LOT 2, STERLING RECYCLING FACILITY

SITE DEVELOPMENT PLAN

PPR2341

SITE DEVELOPMENT PLAN

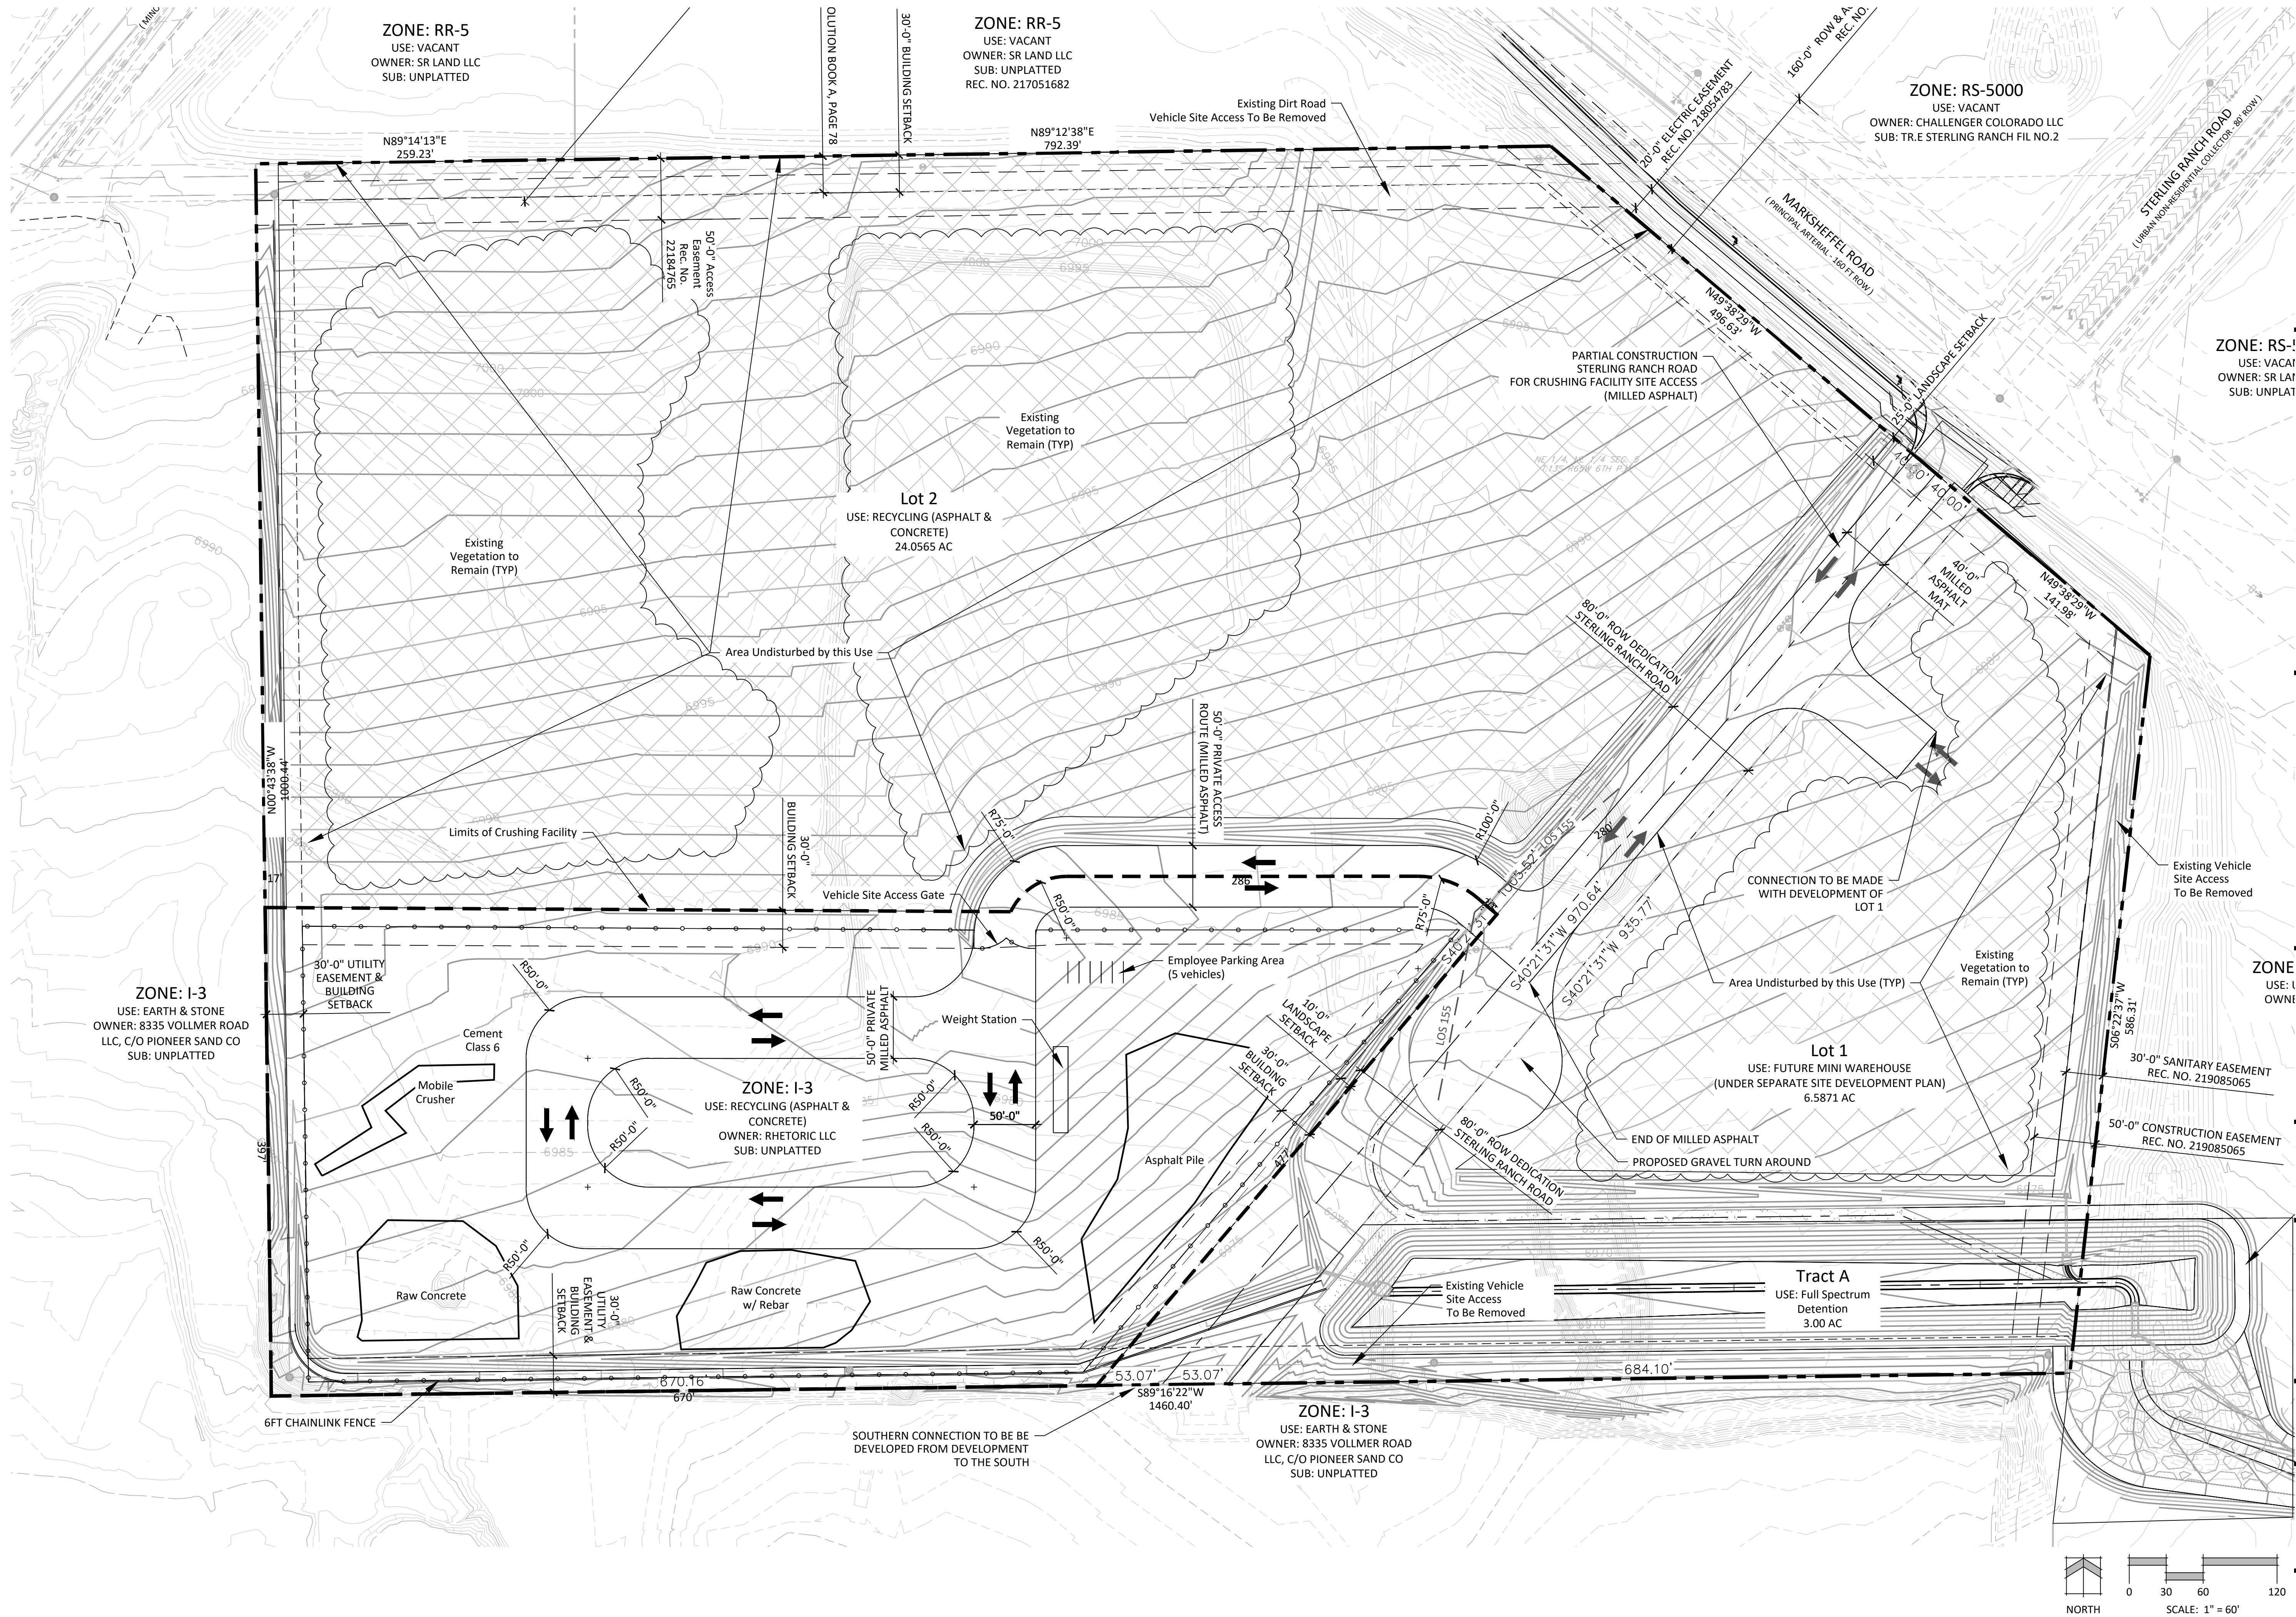
Denote completion or proposed for this pipe. Provide note See comment in the FDR

NES: THIS CALLOUT IS PROVIDED ON THE APPROPRIATE UTILITY SHEET (#3) IN THIS SDP SET AND HAS BEEN ADDED TO THIS SHEET.
